William Parker
554 McNeill Mill Rd.
Broadway, NC 27505
Re: Parker's Pizza

The plans for this facility have been reviewed and are approved with the following conditions:

Jamie Turlington, REHS
Harnett County Environmental Health
Harnett County Health Dept.
(910) 893-7547

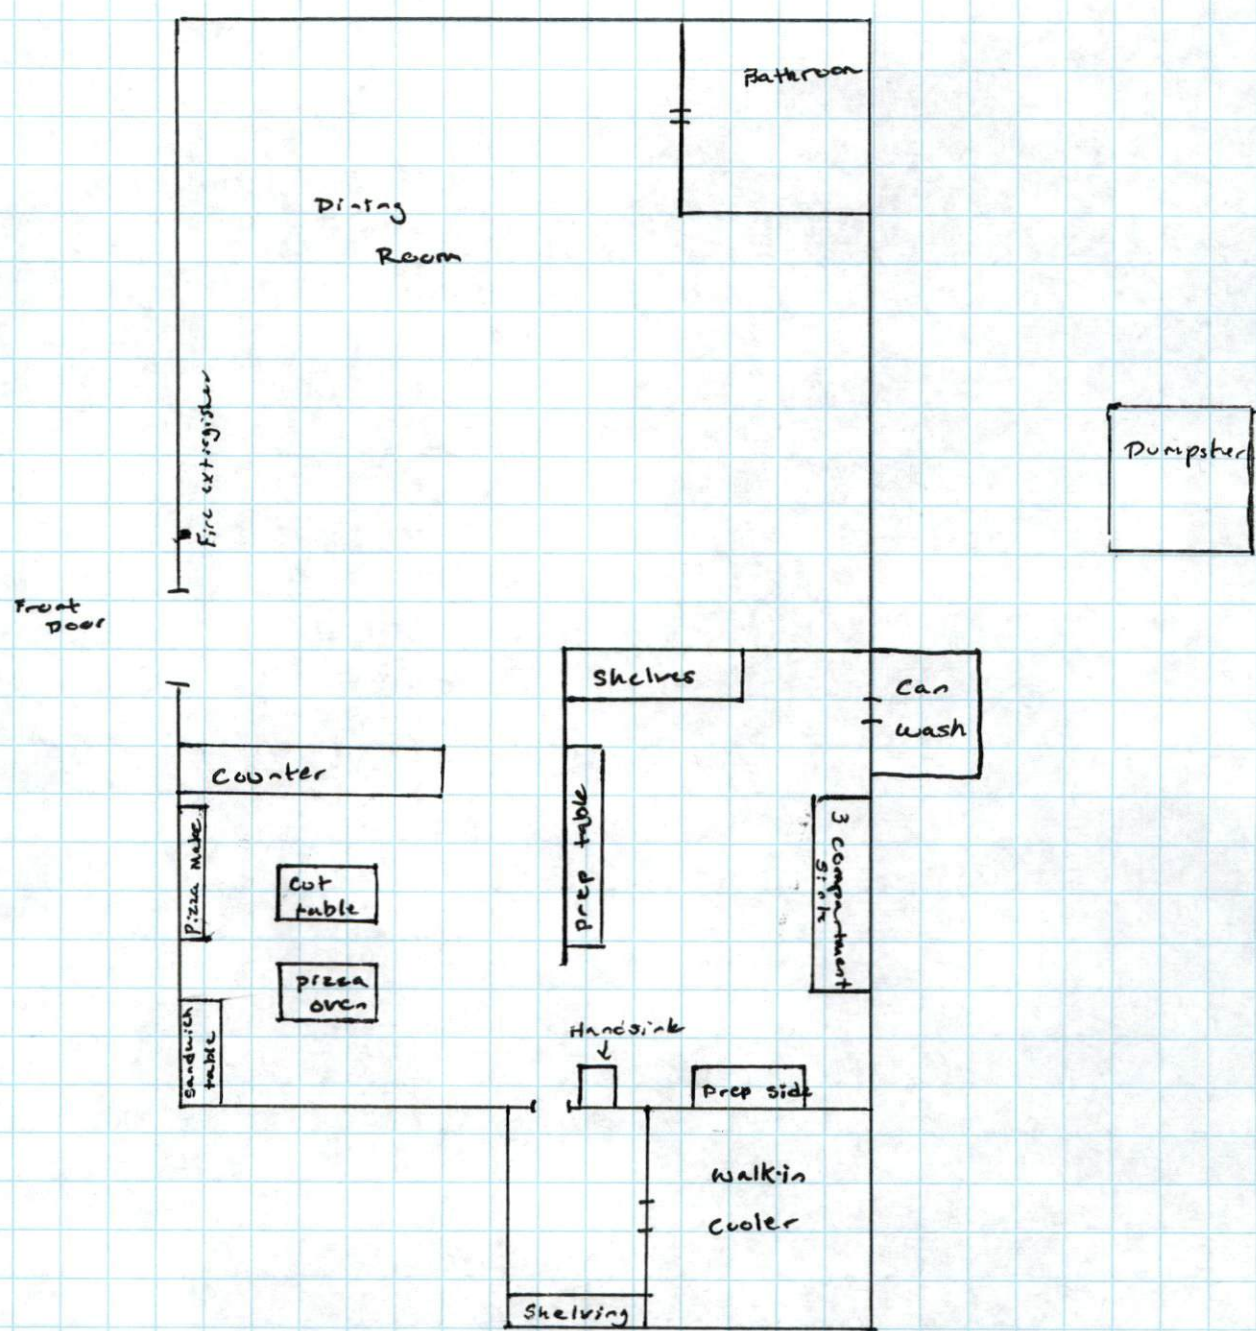
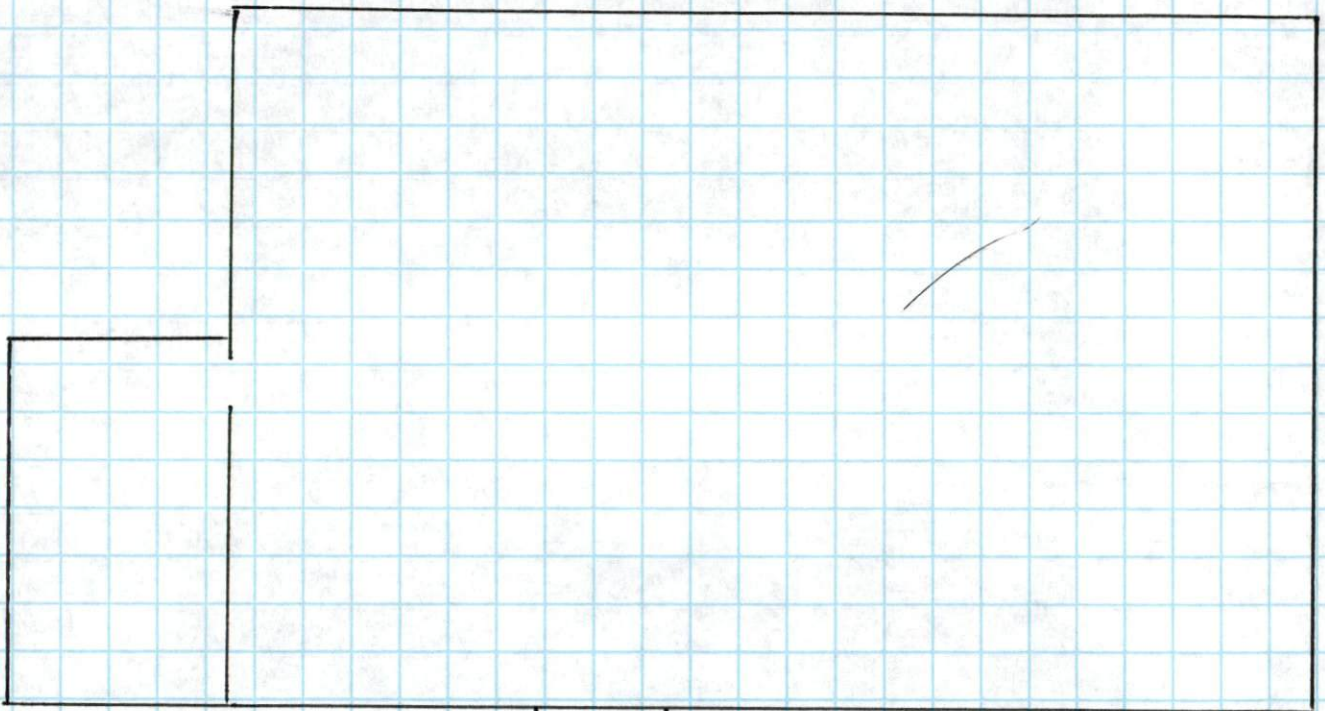
6-The dumpster shall be stored on a nonabsorbent surface, and must be A concrete dumpster pad shall be provided or ensure the dumpster is stored on a surface of nonabsorbent material, such as concrete or asphalt. The surface shall.
